**From:** "Vincent Veroneau" <veroneau@jbbrown.com>  
**To:** "Jean Fraser" <JF@portlandmaine.gov>, "Barry Stowe" <barrys@opechee...>  
**CC:** "JasonBlais" <jasonb@opechee.com>  
**Date:** 5/9/2014 4:11 PM  
**Subject:** RE: FW: Exterior signage CY Portland

From: Jean Fraser [mailto:JF@portlandmaine.gov]  
Sent: Friday, May 09, 2014 3:50 PM  
To: Barry Stowe  
Cc: Vincent Veroneau (veroneau@jbbrown.com); JasonBlais  
Subject: Re: FW: Exterior signage CY Portland

Jean – Please see attached for the Signage and Wayfinding Plan to satisfy a condition of the approval. Please call if you have any questions.

**SIGNAGE &  
WAYFINDING PLAN**

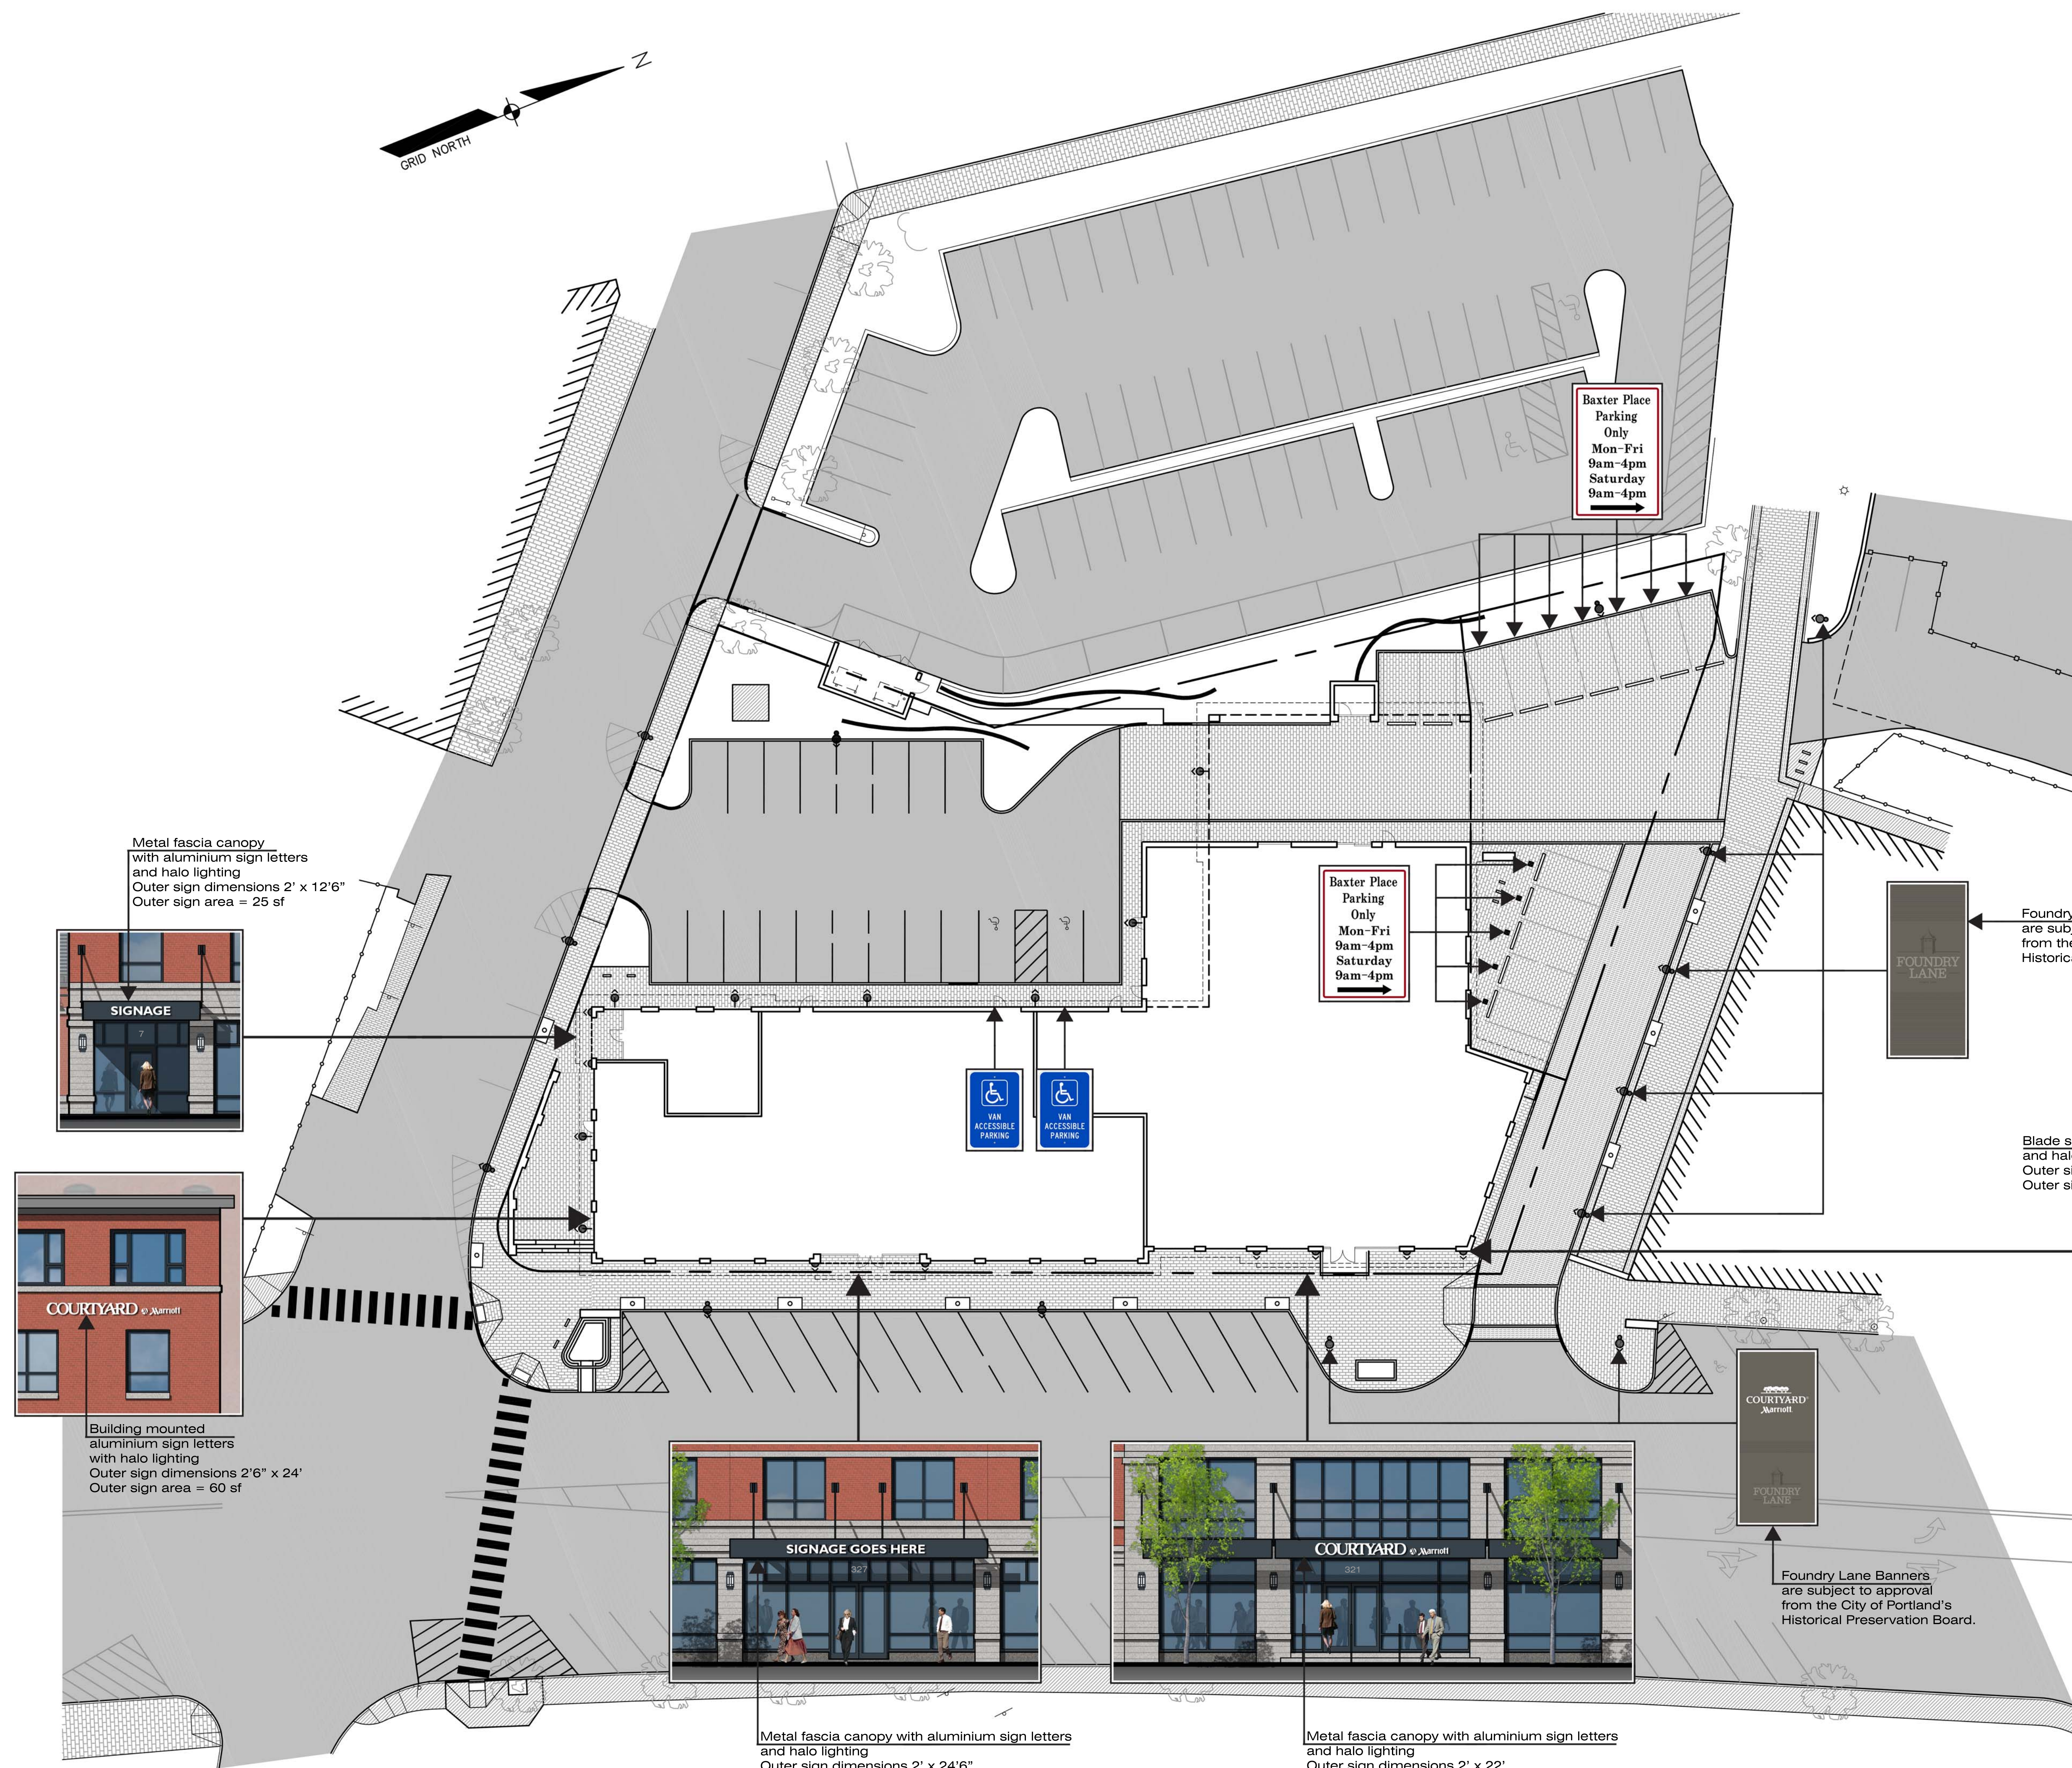
The purpose of this condition/plan is to help those looking for the restaurant, residences or hotel to know where to go - both in terms of entrances and in terms of which drive access to use and where to park.

So we aren't just looking at where on the building it goes (though HP need to review that- has what you sent gone to Deb?) but what it says and the plan needs to include freestanding and other signs that direct the different users as I mentioned above.

I recall that during the TMP scoping meeting Tom Errico was concerned that people driving from the west would not know how to get to the port cochere (sp?) (and would turn into maple un-necessarily) and for cars leaving he wanted them to know which exit was best if they were going east /west (so to minimize left turners from Foundry onto Commercial).

So the plan needs to be more detailed and cover a greater range of signs...

I think we discussed that the large vertical Marriott sign on the property would be the marker to direct cars to come to the Foundry Lane entrance, as it is right on that corner. By adding the banners it provides a very good way finder for guest to know where to turn at Foundry Lane. The hotel website will also direct guest driving to the site to enter via Foundry Lane. I have sent the banner design to Deb, but have not heard back yet. We were waiting for her general approval of the concept before finalizing the sign permit.

The hotel guests are 100% valet (other than the ones we pick up with the courtesy van), so the attendants will determine from the guests which direction they will be heading and will then have the vehicle ready to leave the site in the most efficient way. For example, a vehicle leaving the hotel and heading west, will exit Foundry Lane and take a right. A vehicle heading east will be directed to exit taking a right turn on Maple Street and then a right turn on York to then have the benefit of lighted intersections heading east. I do not believe there is a signage program that would be as efficient as what the valet will provide. I believe this is consistent with our discussions with Tom.
